**BERESFIELD BATTERY ENERGY STORAGE SYSTEM (SSD-31940756) 53  
WEAKLEYS DRIVE BERESFIELD**

I refer to the Department of Planning and Environment's (DPE) notification of 31 May 2023, via the Major Project Portal, advising it has received an Environmental Impact Statement (EIS) for the development of a 170MW/340MWh battery energy storage system (BESS) and grid connection on land known as 56 Weakleys Drive Beresfield. The State significant development application (SSD-31940756) and EIS was being publicly exhibited and City of Newcastle (CN) has been invited to provide advice on the development.

APPENDIX 1: GENERAL DEVELOPMENT LAYOUT

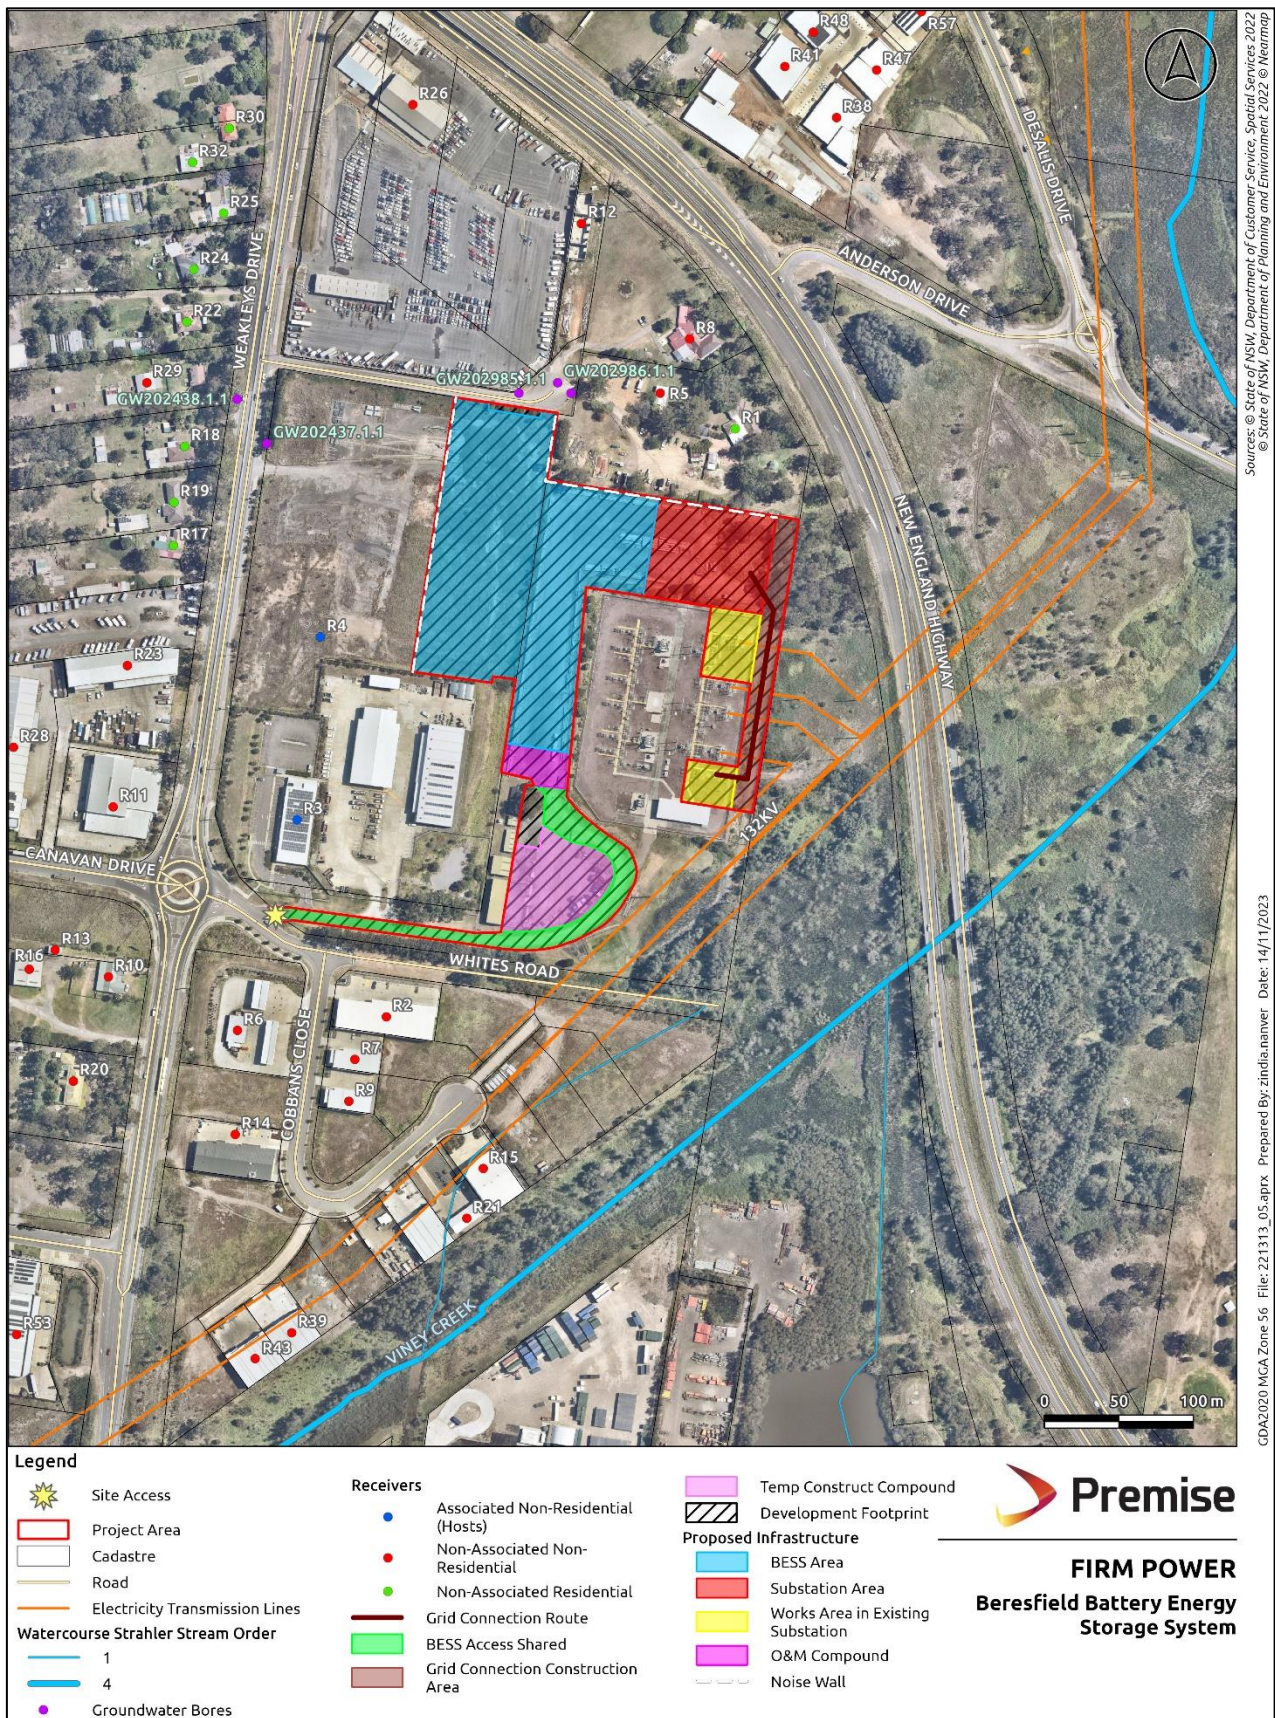
Concern is raised regarding the lack of detailed plans of the development submitted with the development application. The proposed development appears to be at a conceptual stage with many aspects to be the subject of detailed design sometime in the future, including the following:

- Number and exact layout of the battery modules.
- Location of site office and parking.
- The final location, design and height of the noise barrier.
- Location of security fencing and gates.
- Outdoor security lighting.
- Location of easements on the subject site.
- Location of the proposed sub-transmission line.
- Extent of earthworks.
- Preliminary stormwater management plan.

It is requested that the applicant be required to provide supplementary detailed plans which address the above matter.

APPENDIX 3: ROAD UPGRADES AND HAULAGE ROUTE

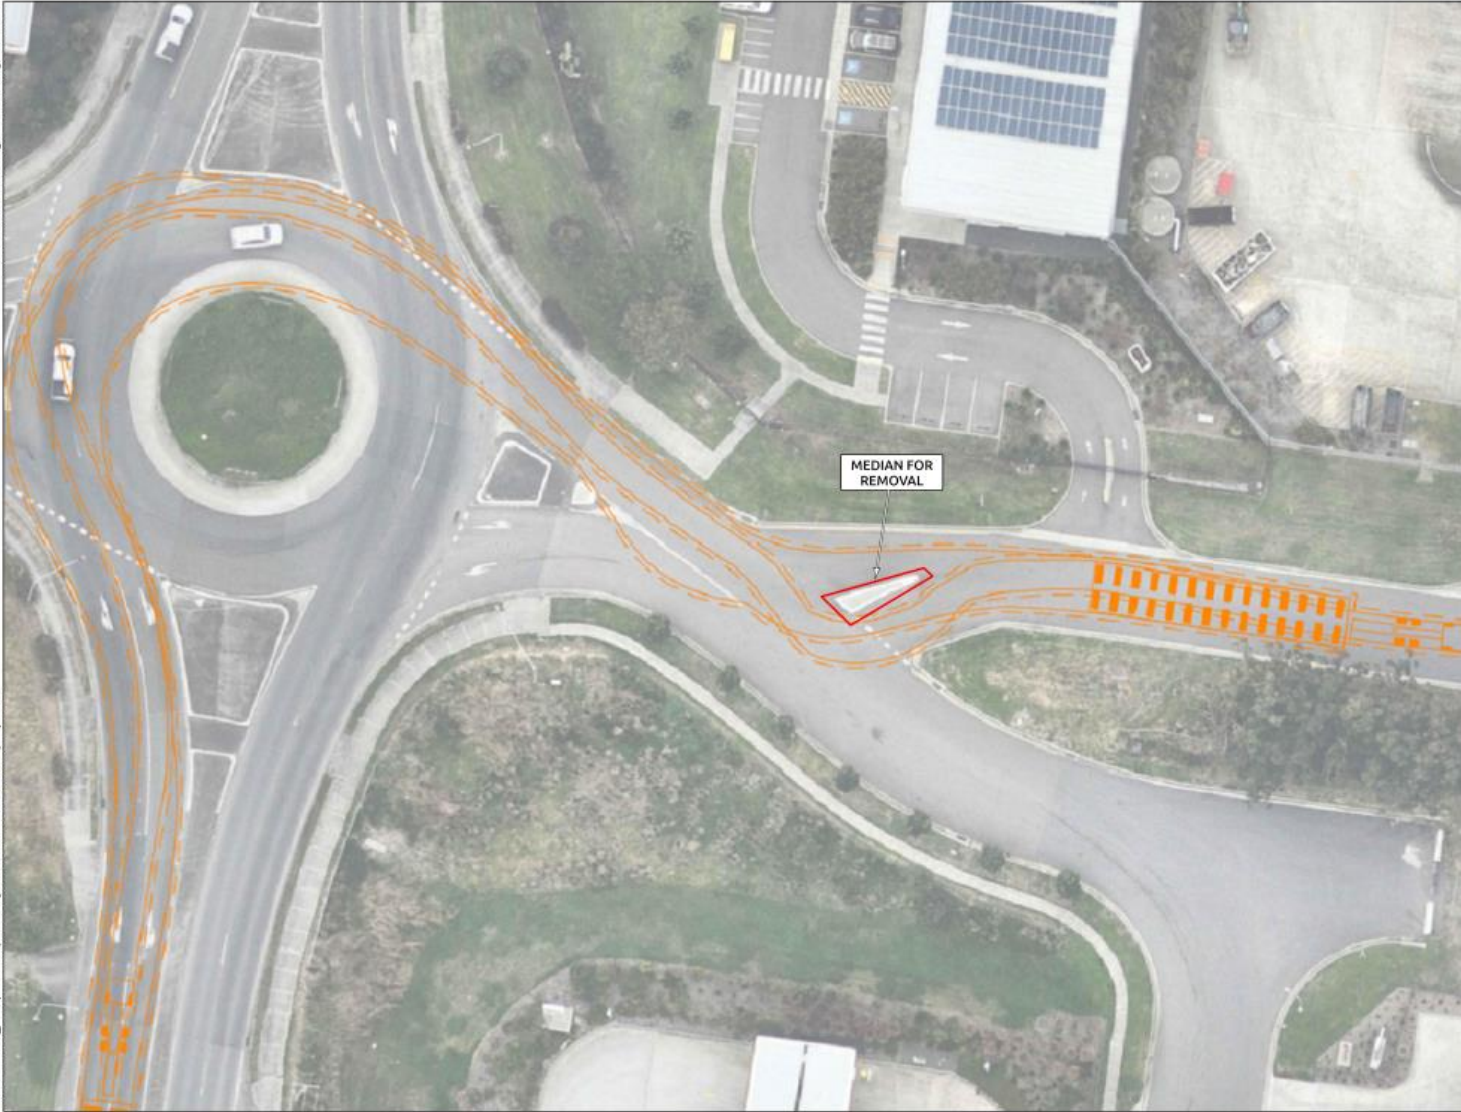
The Swept Path Assessment diagrams (Appendix C of the TIA) indicate the oversized/overmass (OSOM) vehicle will conflict with an existing median island at the intersection of the private access road (in 53 Weakleys Road) and Whites Road. This median island moderates traffic from the private access road but is situated mostly in the public road reserve. Stamped civil plans under RA2018/00214 indicate the median was constructed using 130mm high mountable kerb specified against CN's Standard A1200.

The median may be replaced with a temporary painted median if removal of the median is required to enable access for the OSOM vehicle. If removed, the median is to be reinstated in full (mountable kerb with concrete infill island) prior to the commencement of operation.
